**KIRKLEES METROPOLITAN COUNCIL
INVESTMENT & REGENERATION SERVICE**

DELEGATED DECISION TO DETERMINE PLANNING APPLICATIONS

Reference No:	2025/62/91229/W
Site Address:	29, Birklands Road, Cowcliffe, Huddersfield, HD2 2PF
Description:	Erection of single storey rear extension and dormer
Recommending Officer:	Jennifer Booth

DECISION - REFUSED

Proposed Rear 3D

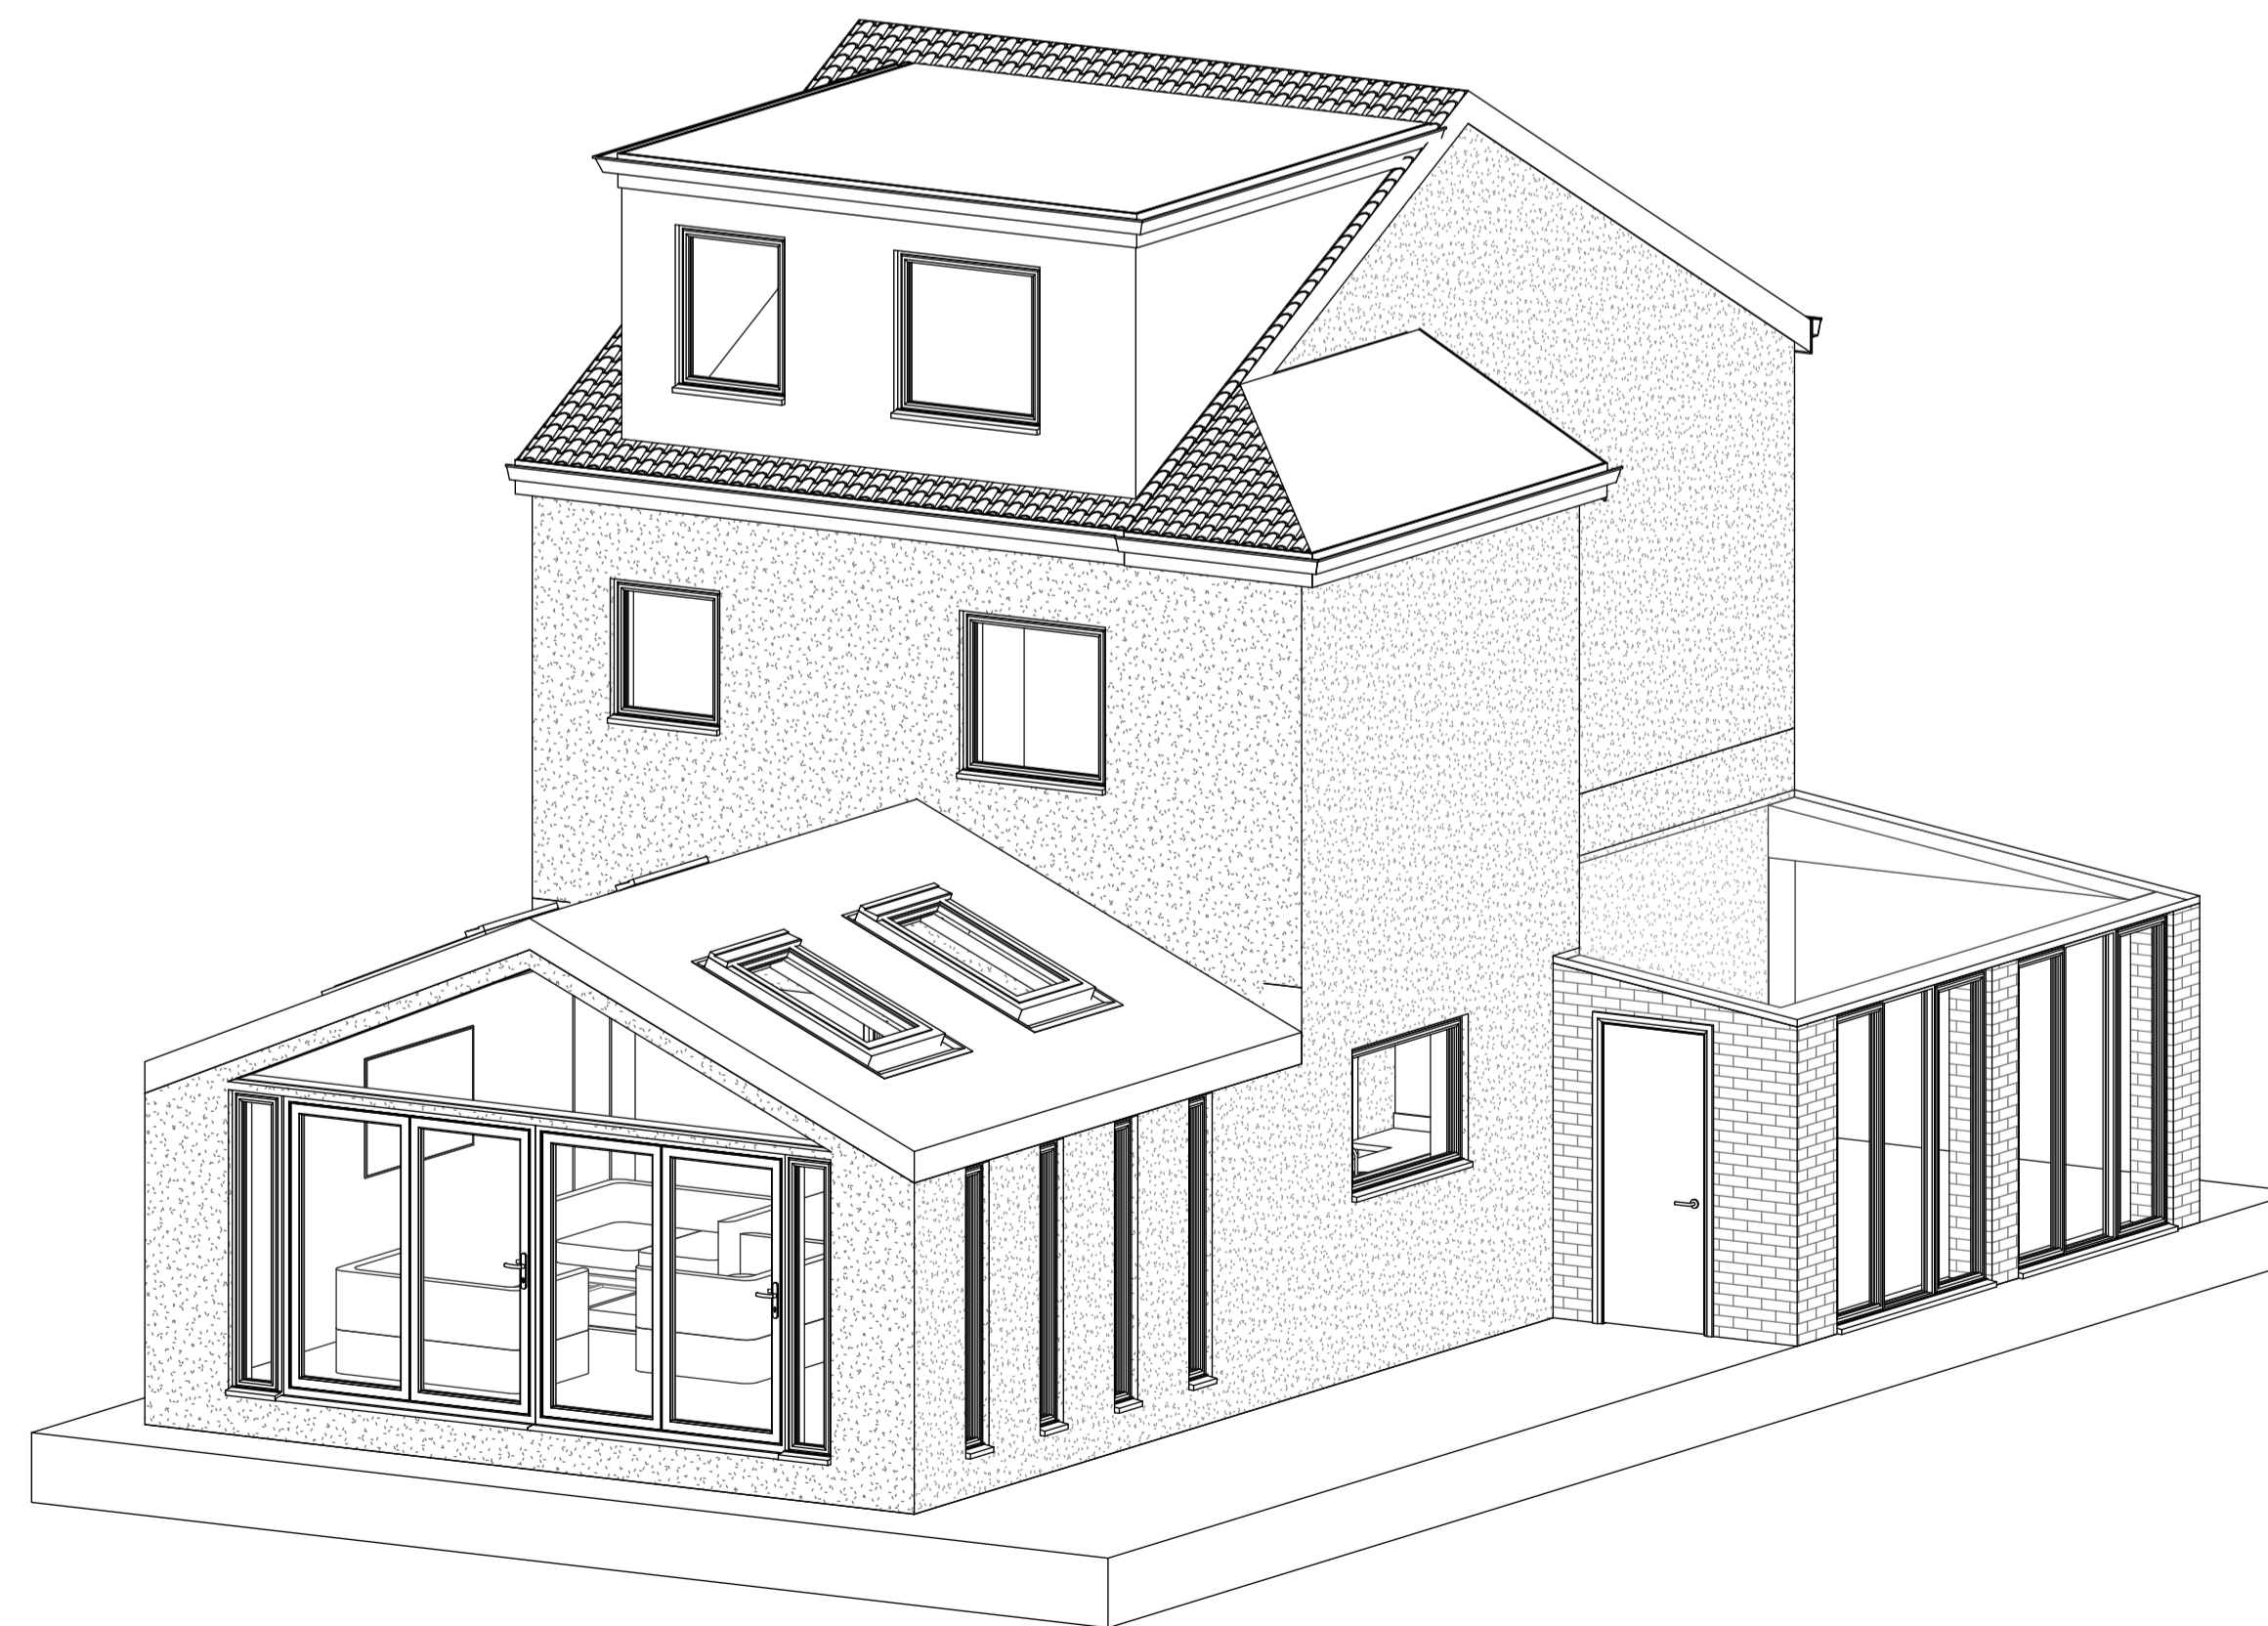
The proposed single-storey rear extension projects further than would typically be supported. The generous size of the rear garden allows the extension to be accommodated without resulting in overdevelopment to the

site per se. However, the projection is significant and the scale and mass competes with the host building detracting from the modest semi-detached property.

The use of matching materials ensures the extension remains in keeping with the character and appearance of the host property, however the projection, scale and mass would detract from the host building and character of the area.

The proposed extension has been constructed on the boundary with 31 Birklands Road to the north-west and projects 5 metres from the rear elevation. Due to its scale and siting, the development is considered to have an overbearing impact on the adjoining property, with the building also affecting the rear elevation and garden area during morning hours through overshadowing. While no windows are proposed in the side elevation facing No. 31, the rear-facing windows would overlook the applicant's own garden, limiting concerns regarding direct overlooking. Nonetheless, the overall impact on residential amenity is unacceptable due to the overbearing and overshadowing effects.

The proposed rear extension, constructed on the shared boundary with 31 Birklands Road and projecting 5 metres from the rear elevation, results in an unacceptable overbearing impact and causes overshadowing of the neighbouring property's conservatory, dining room window and garden during morning hours. To permit the proposals would be contrary to Policy LP24 of the Kirklees Local Plan, KDP5 & KDP6 of the House Extensions & Alterations SPD and Chapter 12 of the National Planning Policy Framework.
